Blacktown Hospital Redevelopment Stage 2

Attachment A - Response to Submissions

1 STAGE 2 MASSING DIAGRAM VIEW 1
0132

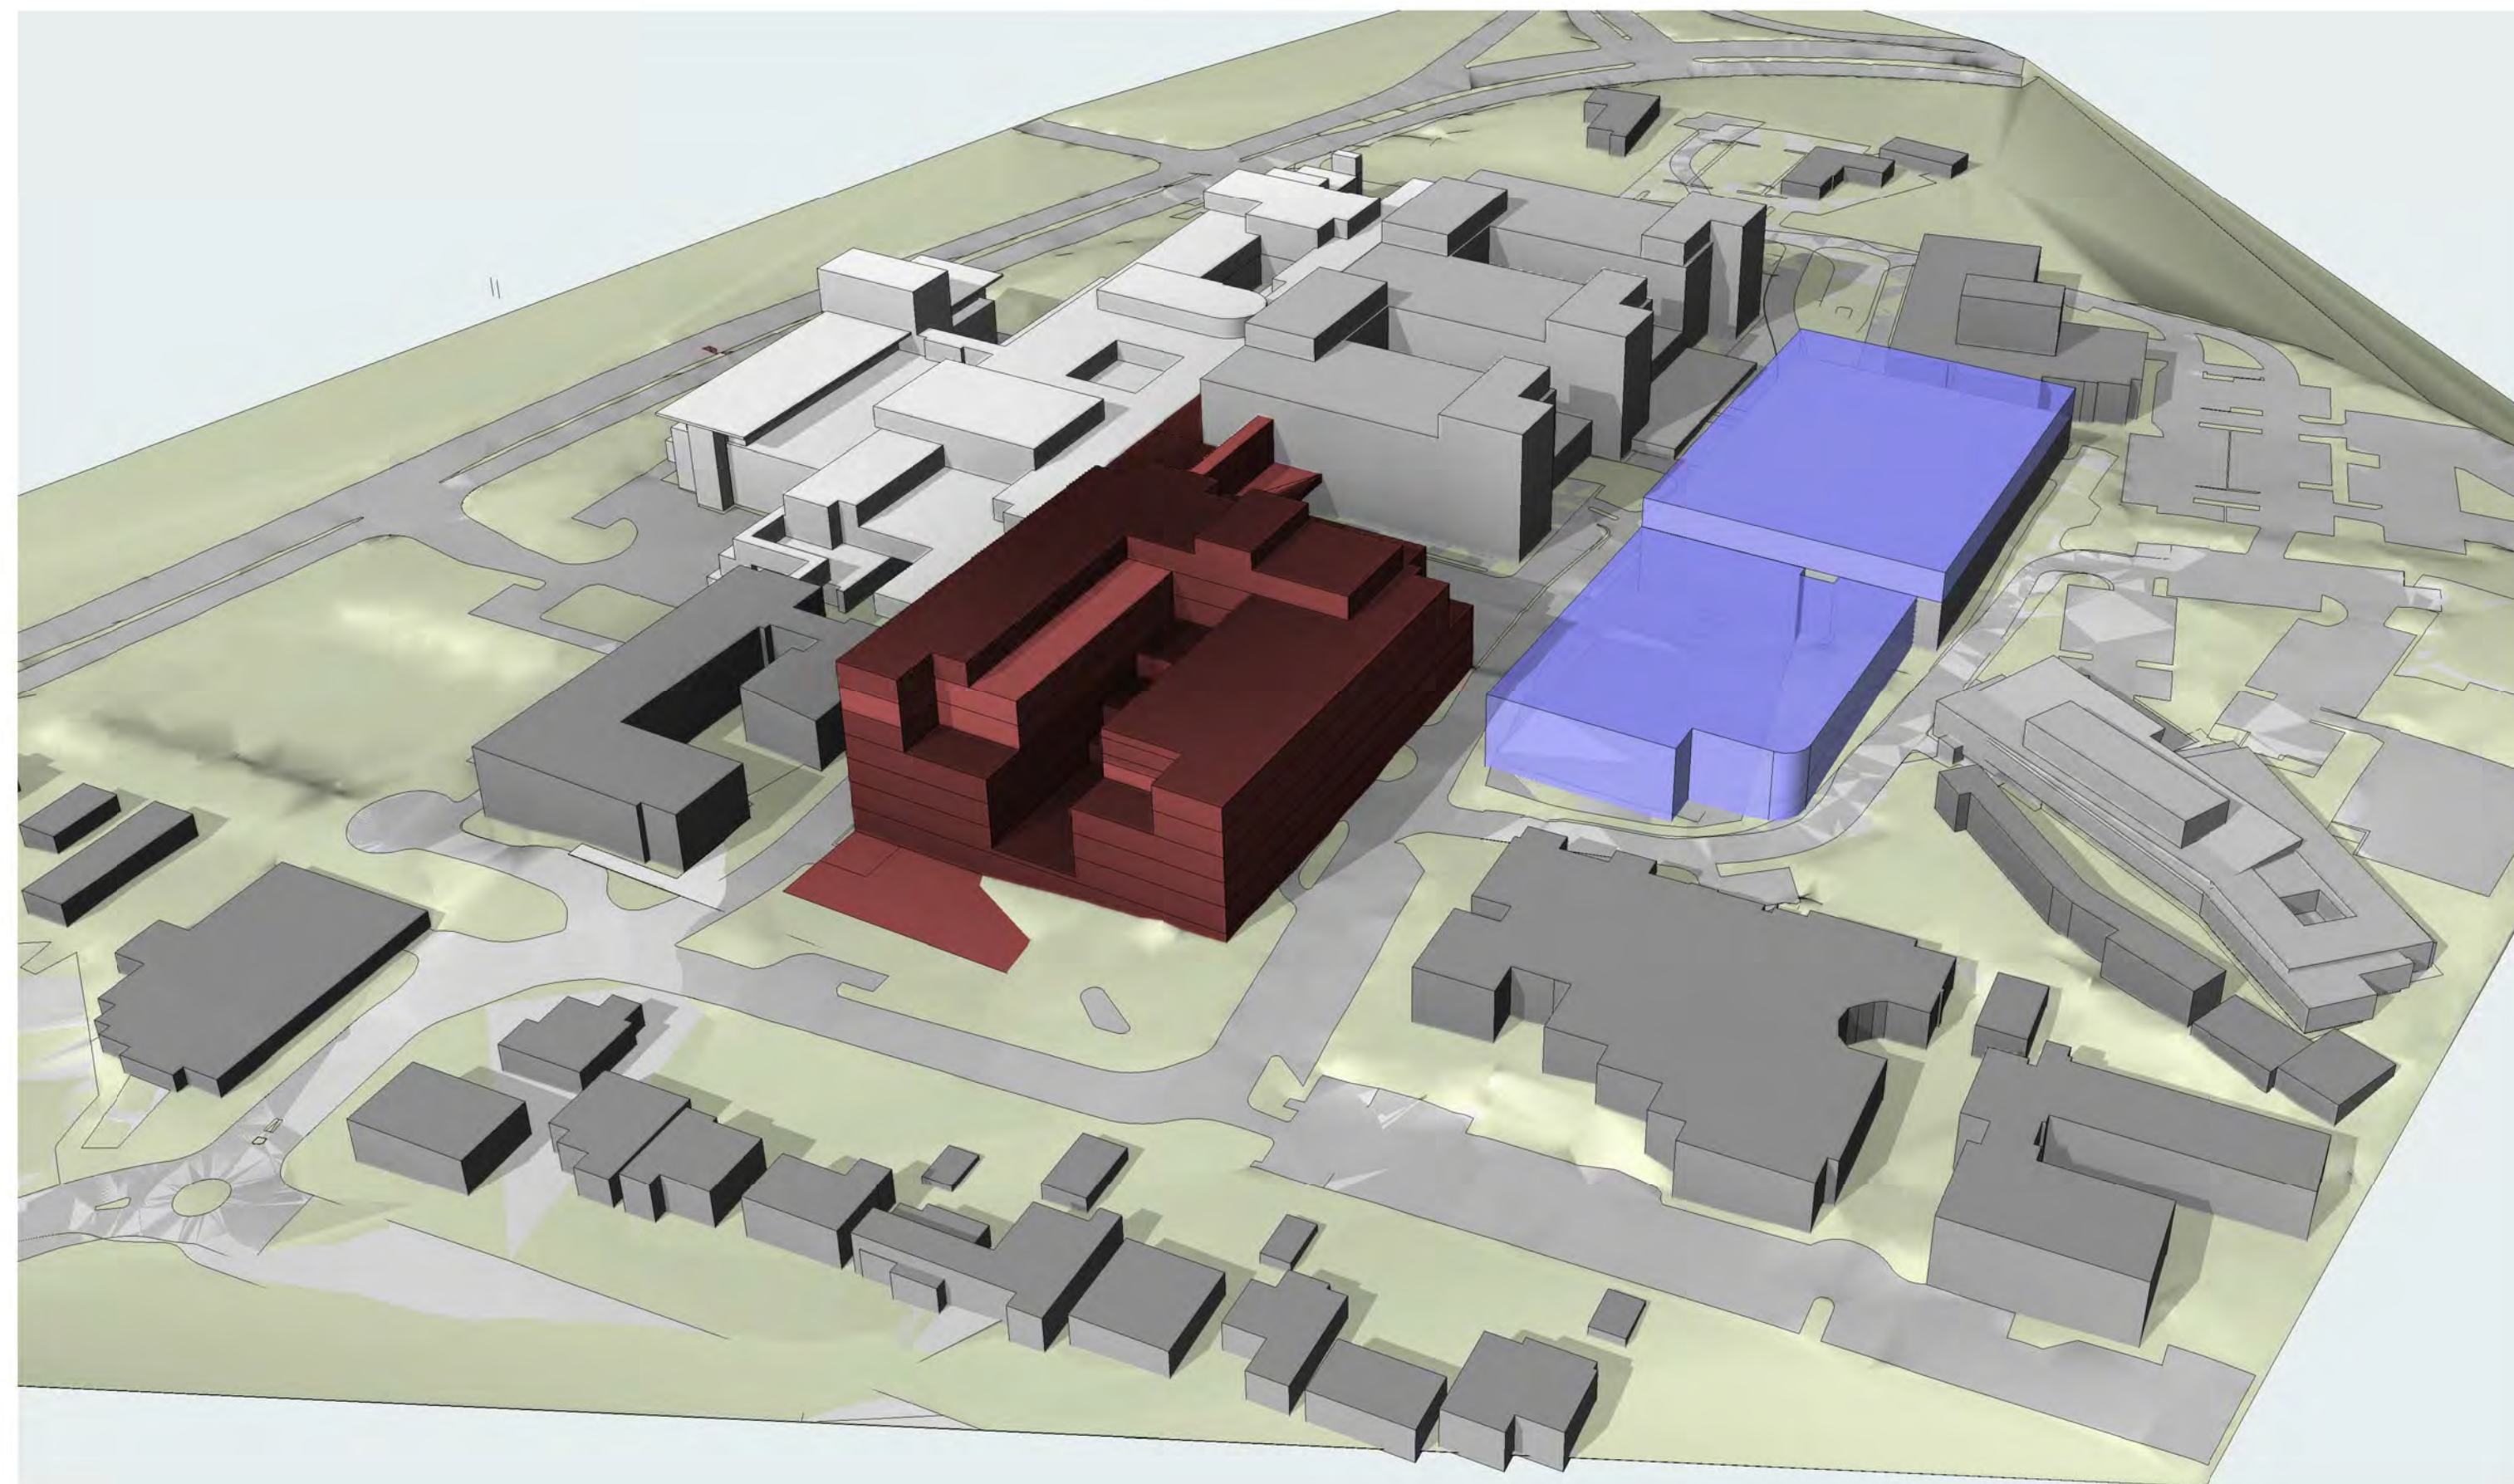
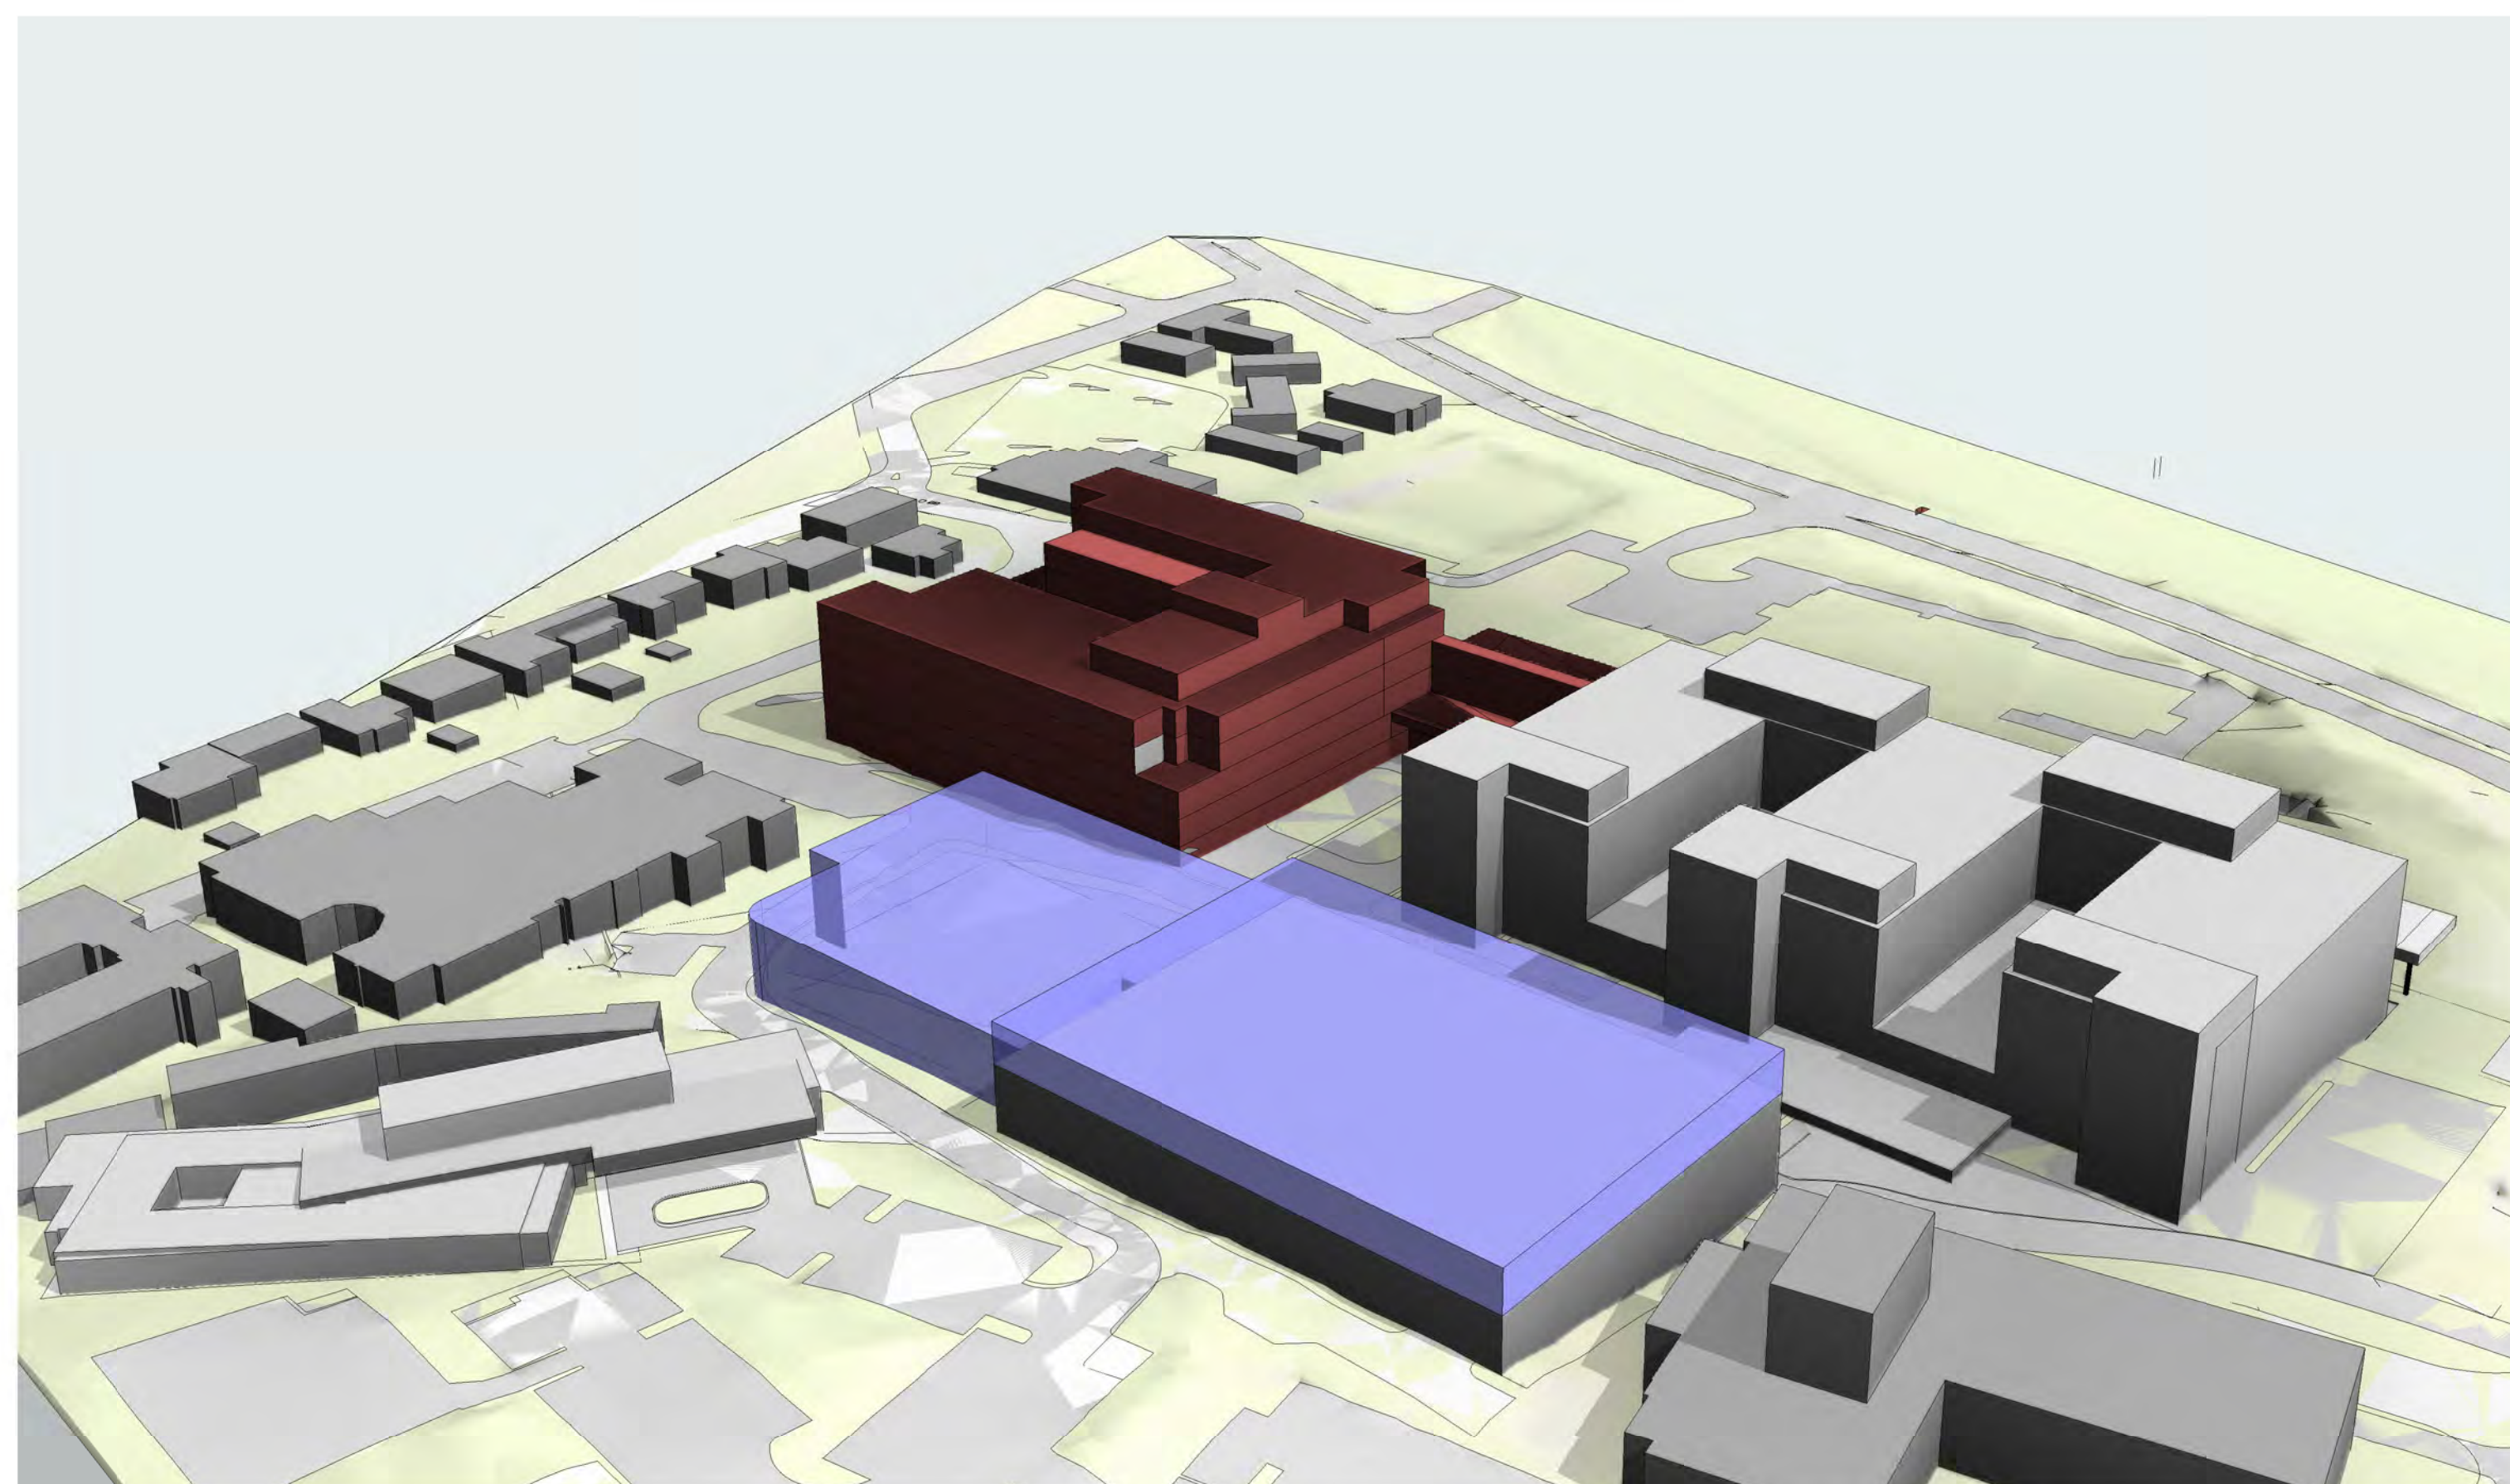
An improved perspective of the Plan -'Proposed View 4 ' with views from various angles is required to gain an improved understanding of the bulk and scale of the	Jacobs has prepared an additional view from further to the east on Blacktown Road, at the intersection with Wall Park Avenue (refer to Attachment C). The view shows that the building will be concealed behind the existing hospital

Issues Raised by Agencies	Response
proposal in context with existing buildings.	<p>buildings, and will not be visible from this location.</p> <p>A range of views have already been provided from along Blacktown Road and Marcel Crescent. Jacobs has considered providing additional views from the east and south of the site, however due to the surrounding topography, the development is not visible from these locations.</p>
Blacktown City Council	
Parking	
The proposal indicates that the parking assessment relies on the availability of all day on-street parking for staff and visitors where they do not wish to utilise on-site paid parking. As previously raised with Health Infrastructure, please be advised that Council will shortly be introducing the trial of a permit parking scheme in the Blacktown Medical precinct. The parking in the streets near Blacktown Hospital will be limited to two hours parking, which is likely to increase the demand for on-site parking for the Hospital.	The parking assessment has not placed any reliance on existing on-street car parking to meet future car parking demand. Instead, the traffic report acknowledges that on-street car parking is currently used where it is available. The future car park expansion on the site will be sized to cater for the expected total car parking demand, as outlined in Section 4.2.5 of the Traffic Report.
